Martin Nugent
01254 828060
D3/12/0063

Drafted 27 March 2012

**Planning Applications, Ribble Valley District
3/12/0063 74 Salthill Road, Clitheroe**

Proposed Site Plan

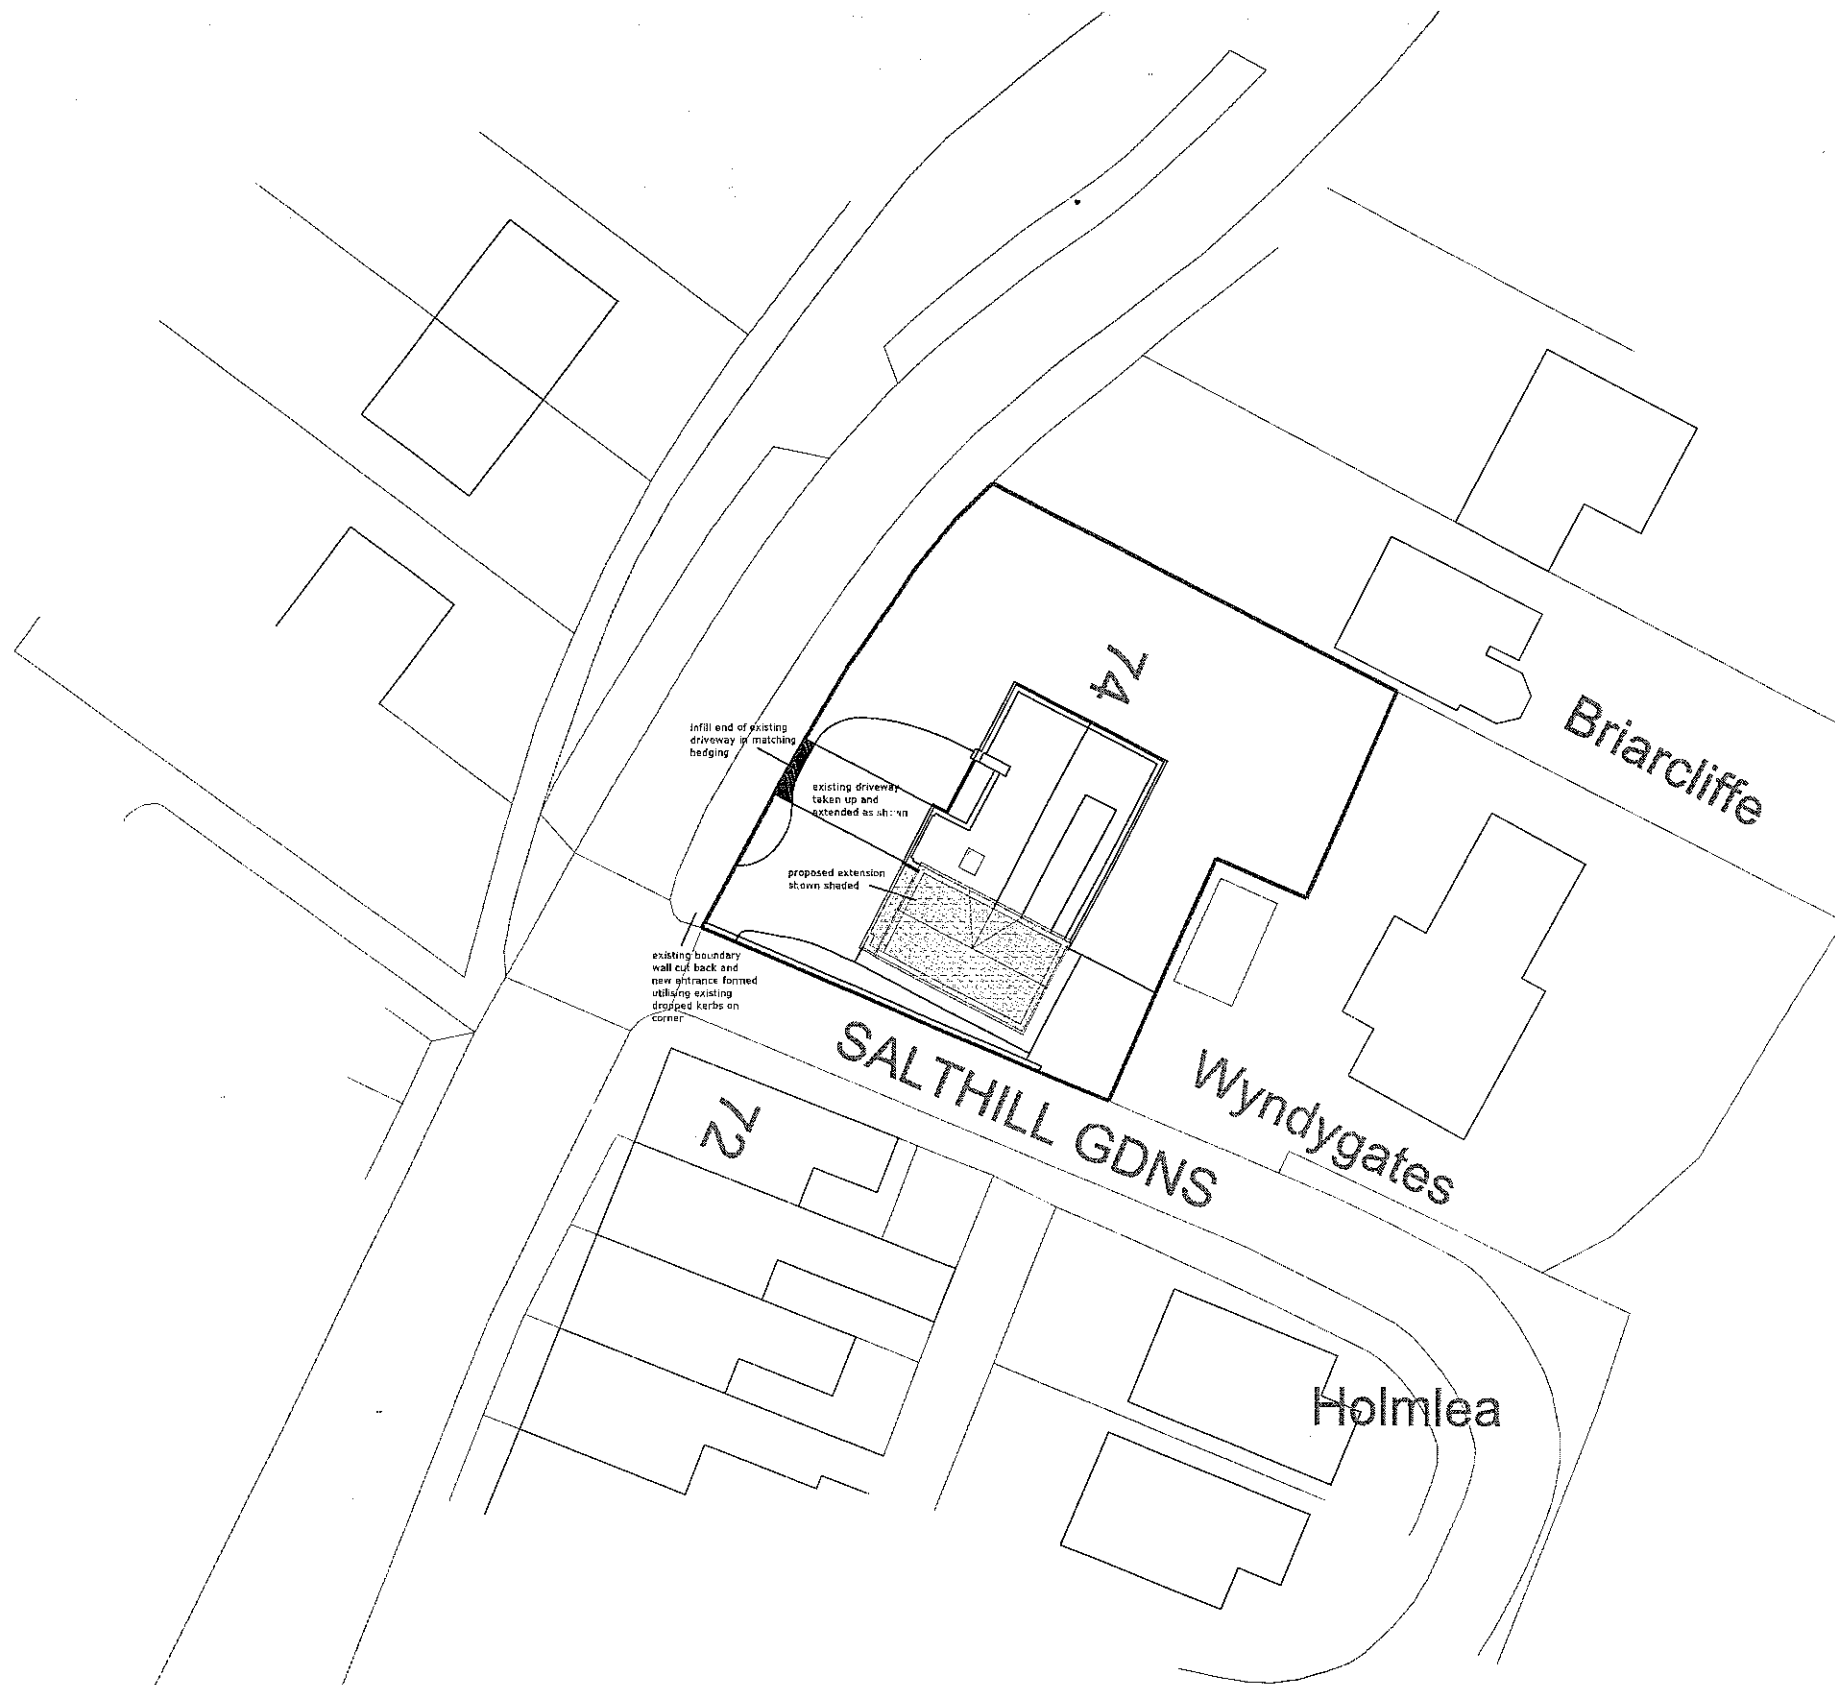
However, the proposed vehicular access aims to utilise, in part, a drop kerb introduced for the benefit of pedestrians. In order that pedestrians are not discouraged from continuing to cross Salthill Gardens at this safe location, I would ask that a Condition be included in any subsequent consent that required the applicant to provide a detailed drawing of the proposed access, including materials, and the full extent of any drop kerbs.

I have highlighted on an attached plan the extent of the existing drop kerbs, along with the extent of the vehicular access. My concern is that the existing drop kerbs do not run for the full length of the access and that access to the proposed driveway will be restricted unless vehicles run over the adjacent full height kerbs. In addition, there is a service cover in the footway to the west of the driveway that is vulnerable to over-running by private vehicles. I would recommend that this chamber be relocated, but this would be determined when considering the possible alterations to the highway detailed below.

The extension of the driveway will require the provision of new drop kerbs and alterations to the footway. The construction and maintenance of these items must be completed in accordance with a scheme to be agreed by the Local Planning Authority in conjunction with the Highway Authority.
